Our Reference: DW019/01 Rev1
Your Reference:

Land to east of Salesbury View Wilpshire – Planning Reference 3/2025/0801
Proposed erection of new residential development comprising 80 new homes, including 30% affordable housing, open space and associated infrastructure.
Technical Review – Highways and Drainage/Flood Risk

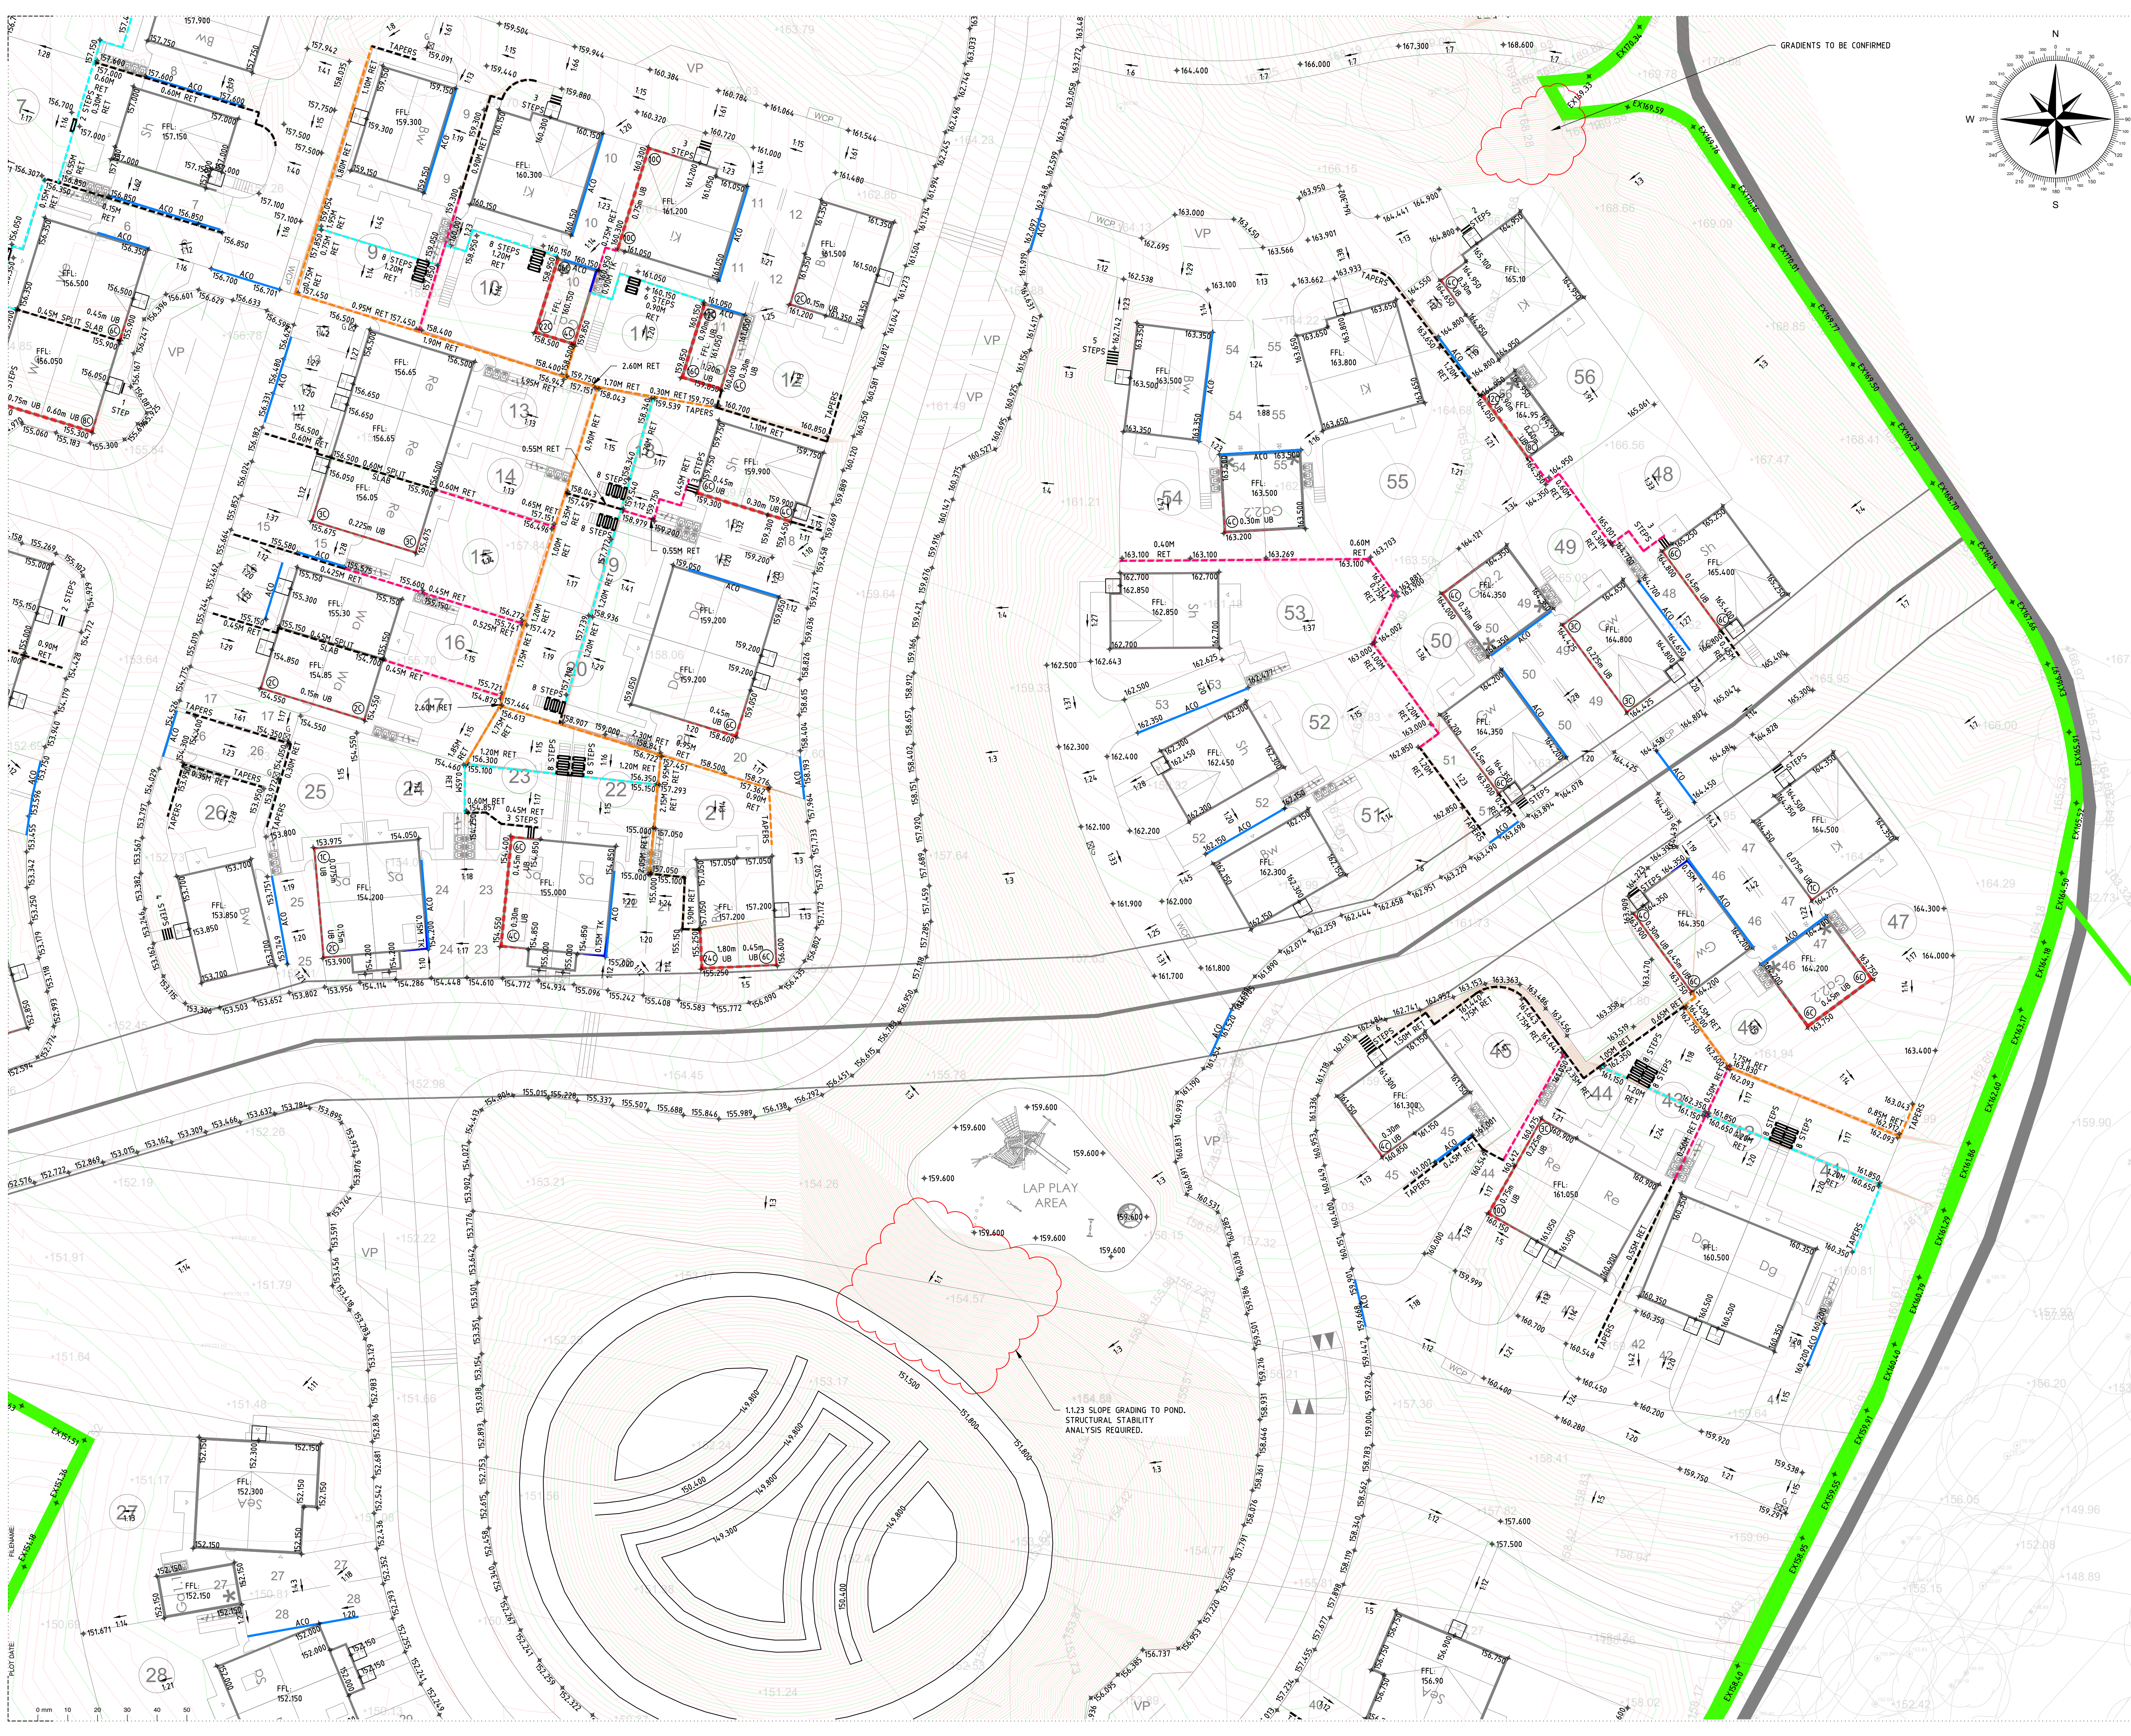
- Finished Floor Levels are 150mm or less from the drainage cover levels

Edge Consulting External Works Plans (210687-EDGE-XX-XX-DR-C-1001 to 1005) clearly show FFLs raised 150mm above surrounding ground levels. Recommended Planning Condition 01(b) also makes specific reference to FFLs being 150mm above ground levels and required site plans showing detailed flood exceedance routes, therefore addressing this issue.
